From: Outhwaite, Jackie [jackie.outhwaite@environment-agency.gov.uk]
Sent: 11 January 2012 13:20
To: Mike Longman
Cc: Davies, Gillian; Browne, Glen
Subject: RE: UPPER HEYFORD - DISCHARGE AUTHORISATION

The proposal has been reviewed and I enclose the Environment Agency's comments on:
Heyford Park, Camp Road, Upper Heyford

LPA ref: 08/00716/OUT

ENQUIRY REGARDING CONDITION 35 OF 08/00716/OUT (APPEAL DECISION 2080594) FOR OUTLINE APPLICATION FOR NEW SETTLEMENT OF 1075 DWELLINGS, TOGETHER WITH ASSOCIATED WORKS AND FACILITIES INCLUDING EMPLOYMENT USES, COMMUNITY USES, SCHOOL, PLAYING FIELDS AND OTHER PHYSICAL AND SOCIAL INFRASTRUCTURE. HEYFORD PARK, CAMP ROAD, UPPER HEYFORD.

Title: As-Built Fuel Distribution Pipeline & Tanks

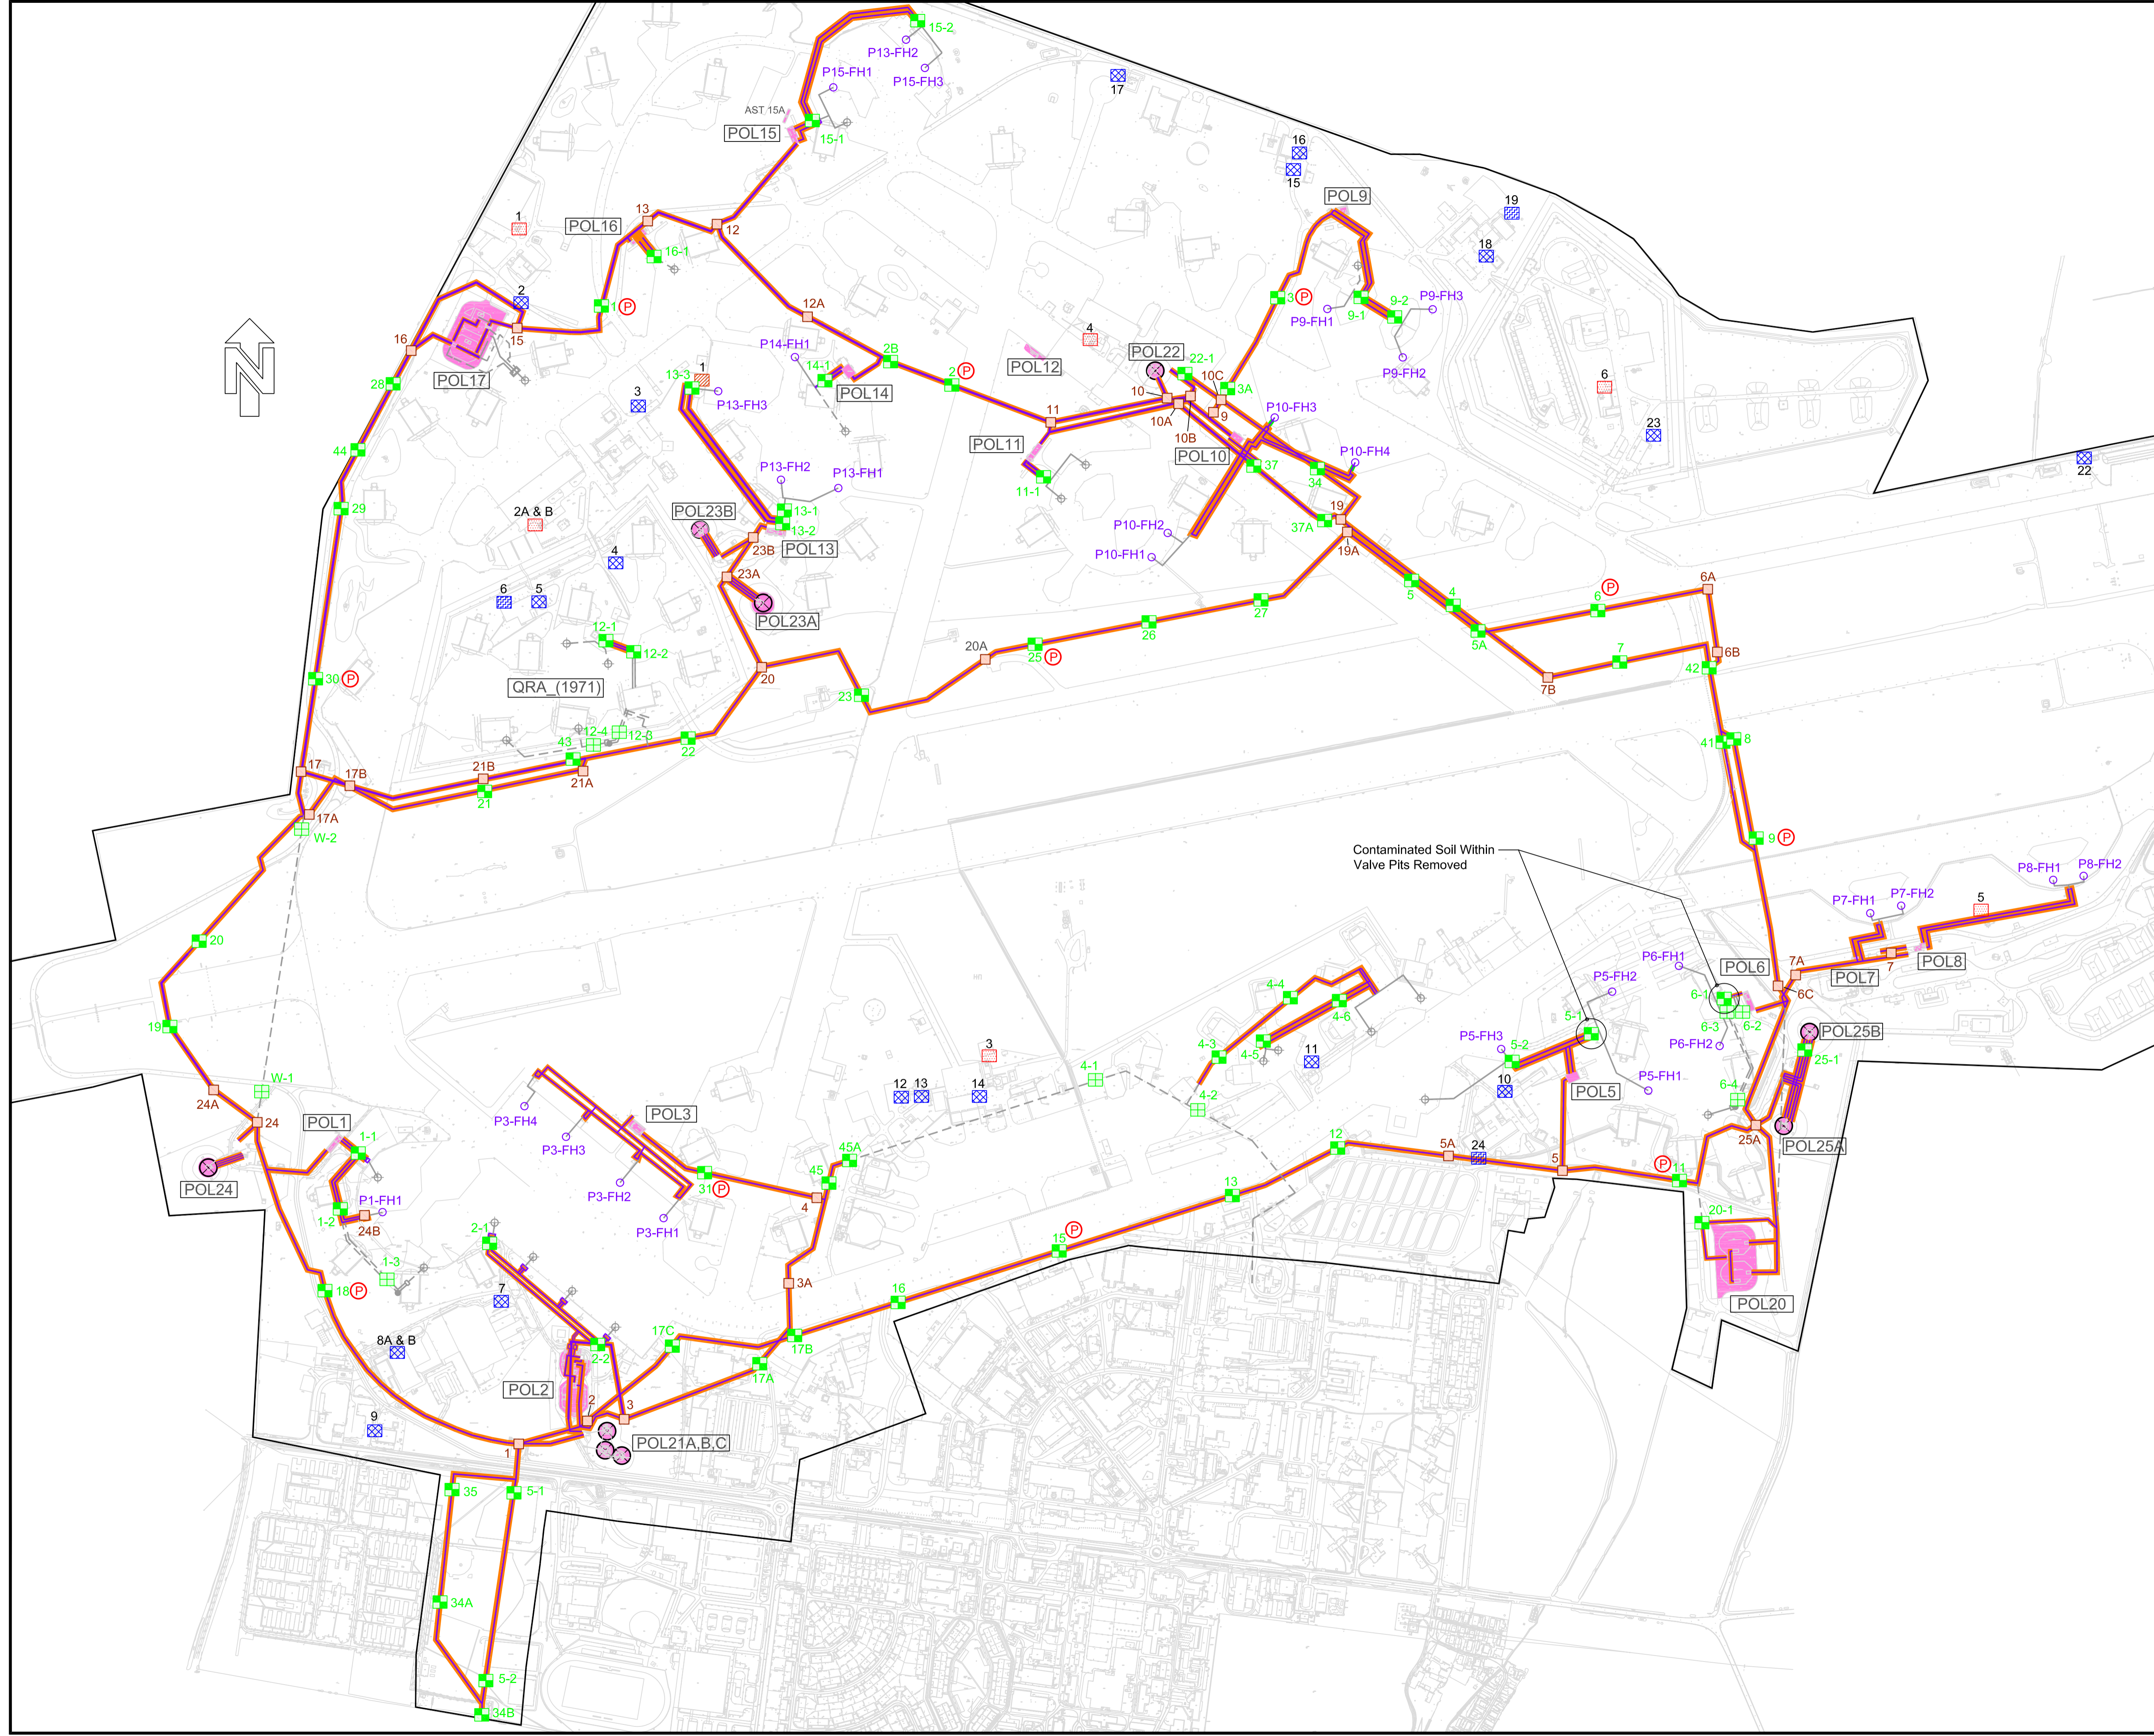
We have now completed all works to the tanks on the above project. Those works have gone well and to programme. Unfortunately, we have encountered significantly greater lengths of pipework in the fuel distribution system causing works to run over our programme.

Whilst the quantity of oily water contained in this extra pipework is small, we must maintain the water treatment plant and the ability to discharge treated water. Our current discharge authorisation is for 16 weeks and these additional works will extend beyond this period. Therefore, we would like to extend the discharge authorisation period for a further 5 weeks.

This extension is for a small volume of treated water involving discharging approximately 5 – 10 m³ every three to four days. Discharge will only be to one discharge area Discharge Area 7 (as we have undertaken the post discharge soil sampling to all other areas).

Mike,
Further to your email request for a five week extension to the time period for your discharge of treated water to ground we are happy to grant this providing all other conditions remain as detailed in Glen Browne's letter dated 13/09/2011. Please inform us when the discharge ceases.
Regards
Jackie
